**WELWYN HATFIELD BOROUGH COUNCIL
EXECUTIVE DIRECTOR - PLANNING, PUBLIC PROTECTION AND GOVERNANCE**

DELEGATED APPLICATION

Application No: 6/2017/2646/PN8
Location: Manor Cottage Vineyards Road Northaw Potters Bar EN6 4PQ
Proposal: Prior approval for the erection of a single storey rear extension measuring 8m in depth, 2.8m in height and 2.541m to the eaves.
Officer: Mr David Elmore

Recommendation: Prior Approval Refused

DRAWN RR **CHECKED** RR **DRAWING No** MC-R00-PR-102

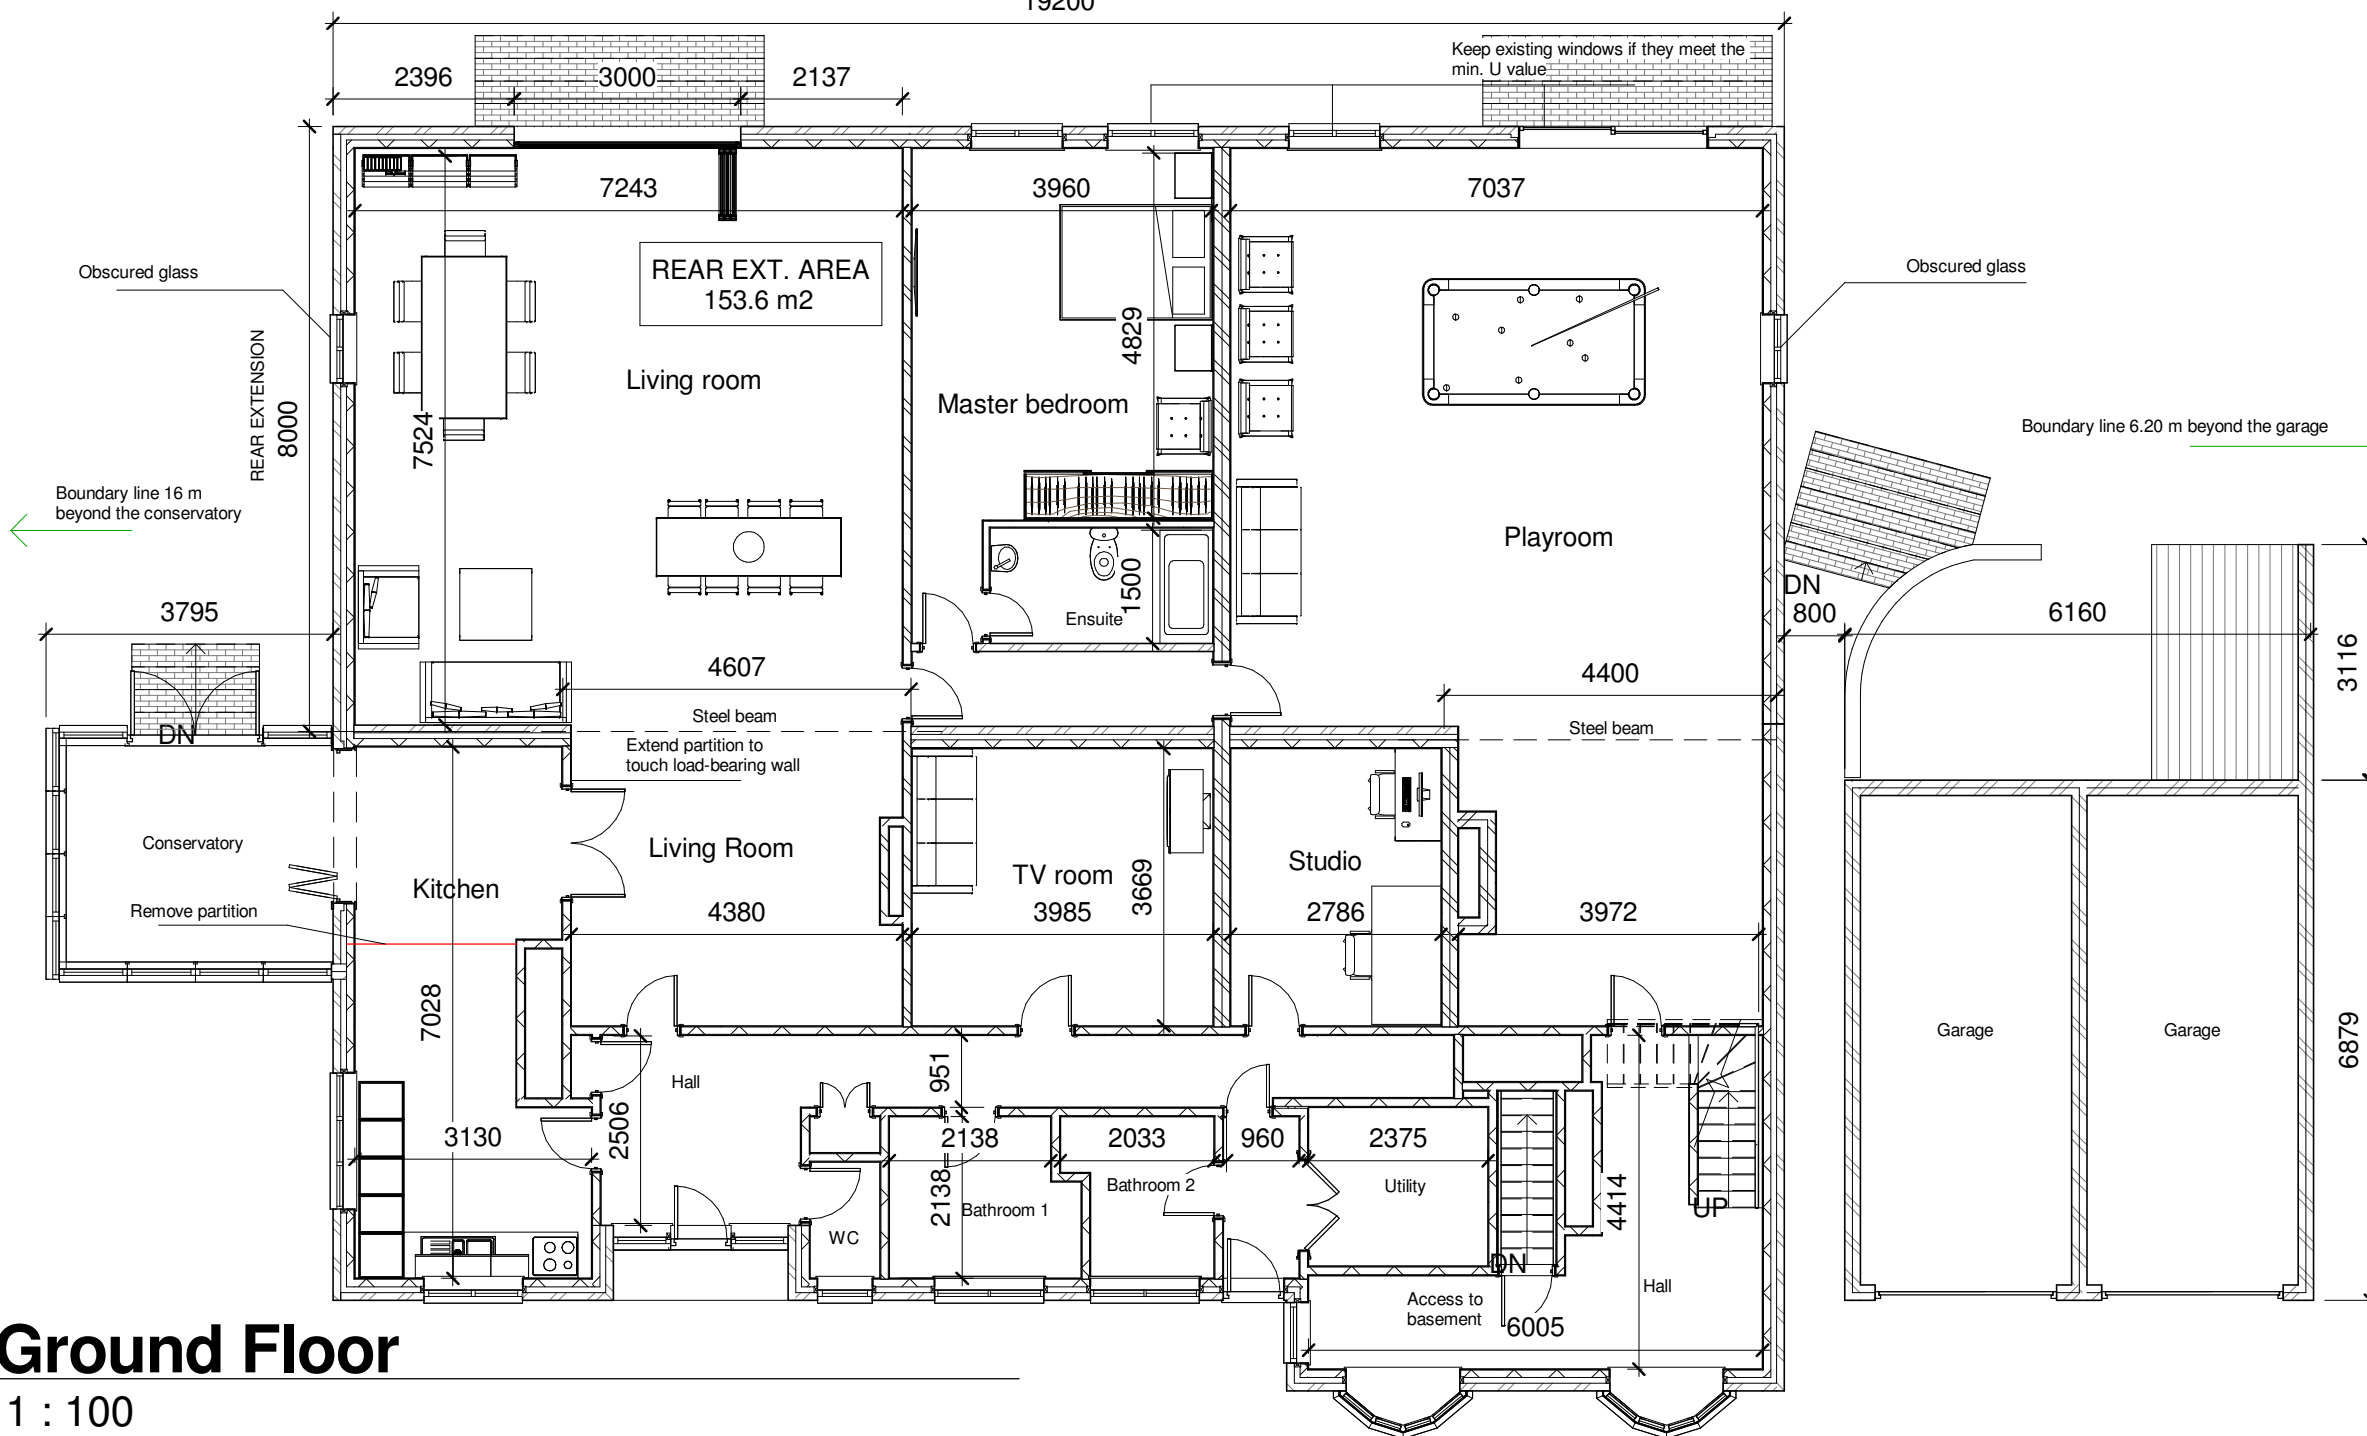
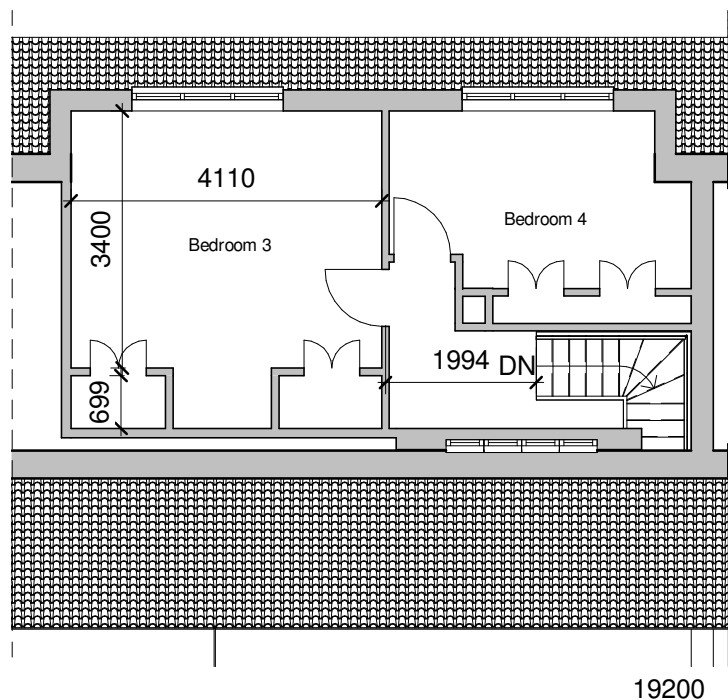
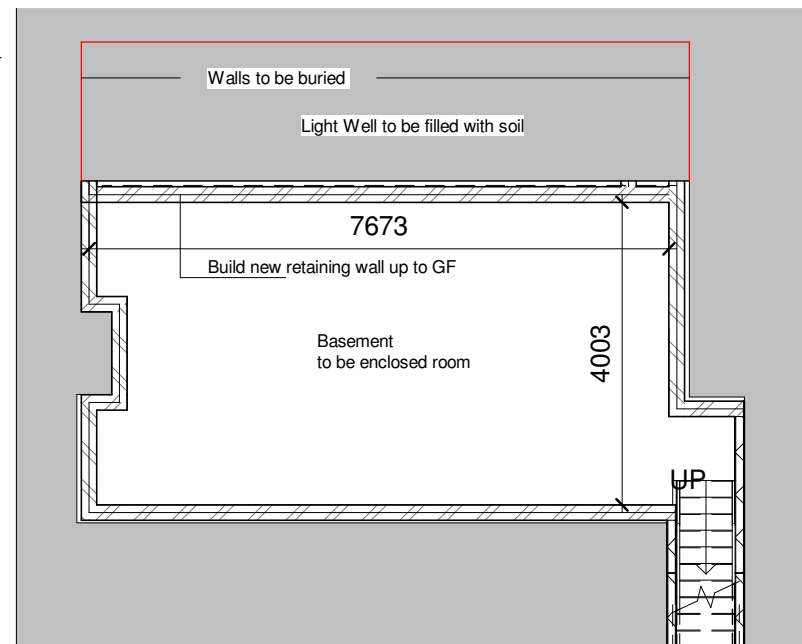
1. The proposed single storey rear extension would be attached to a non-original front and side extension to the subject dwelling. As such, the total enlargement (being the enlarged part together with any existing enlargement of the original dwellinghouse to which it will be joined) would exceed the limits set out in Schedule 2, Part 1, Class A, A.1, h, j and ja of the Town and Country Planning (General Permitted Development)(England)(Amendment) Order 2017.
